Comments for Planning Application 23/04855/FULL6

Application Number: 23/04855/FULL6

Address: 10 Rusdene Walk Biggin Hill TN16 3UG

Proposal: Demolition of existing conservatory. Construction of a single storey front infill extension and single storey rear extension with internal alterations.

PROPOSED FRONT ELEVATION scale 1:100

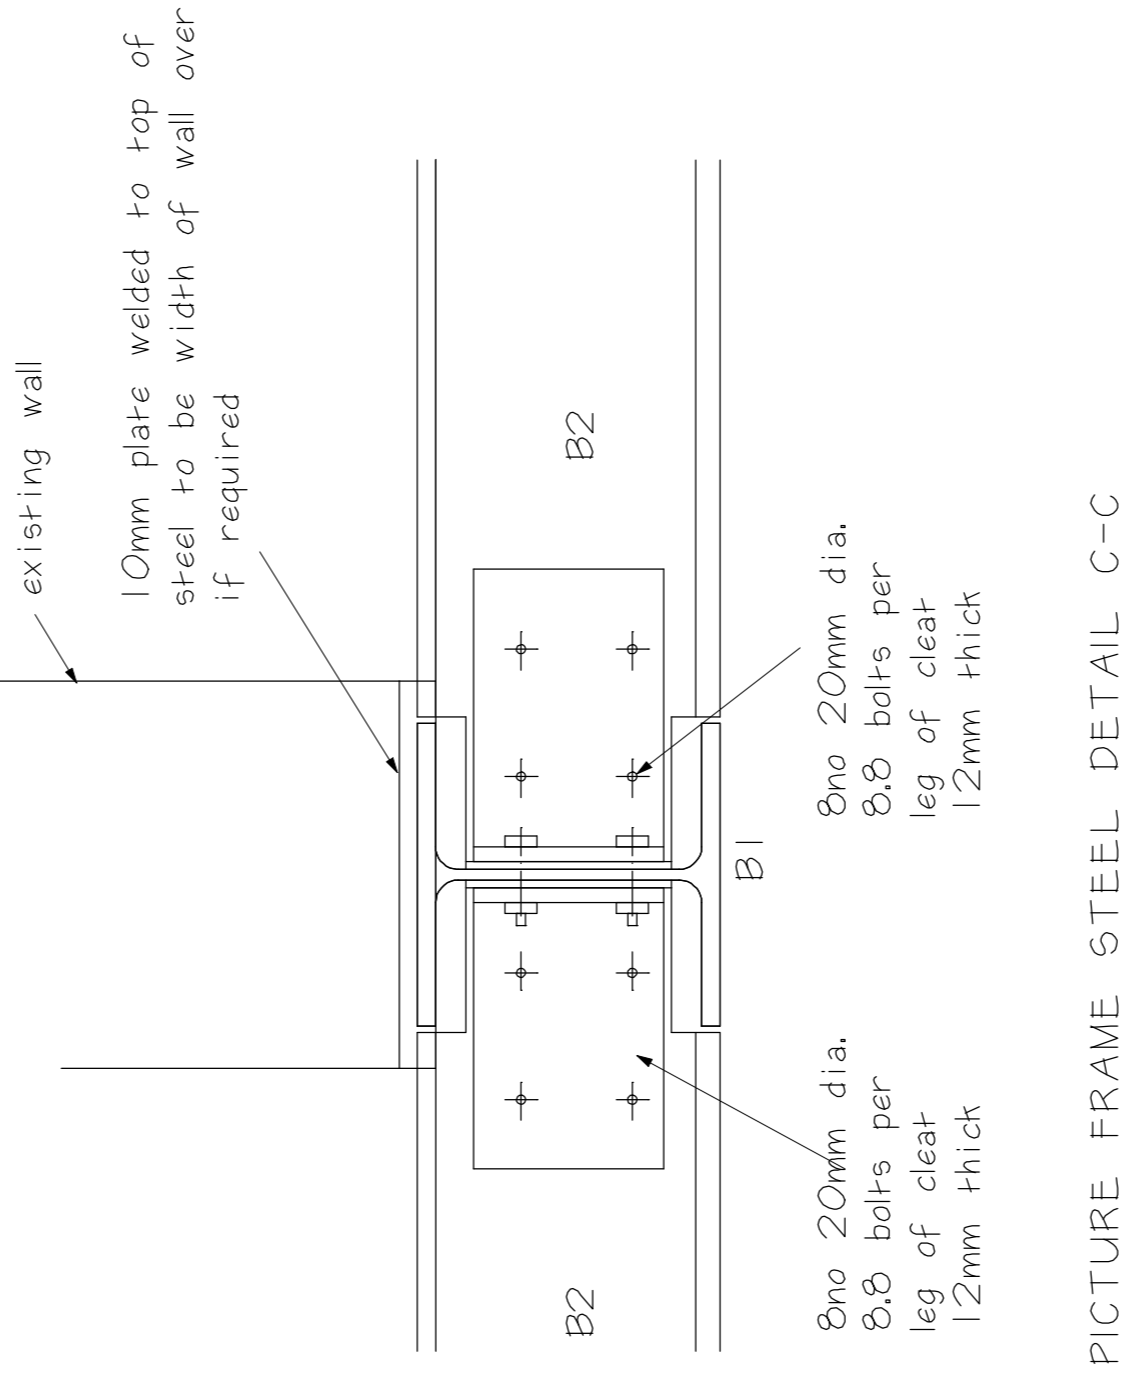
Comment: I object the construction of the single storey front infill extension.

It will significantly affect our light at the front of our property. There will be hardly any natural light in our living area and our view from our window will be a brick wall. It will also completely box in our front door area. Other properties in our street that have built this extension at the front of their property did so at the same time as their adjoining neighbour.
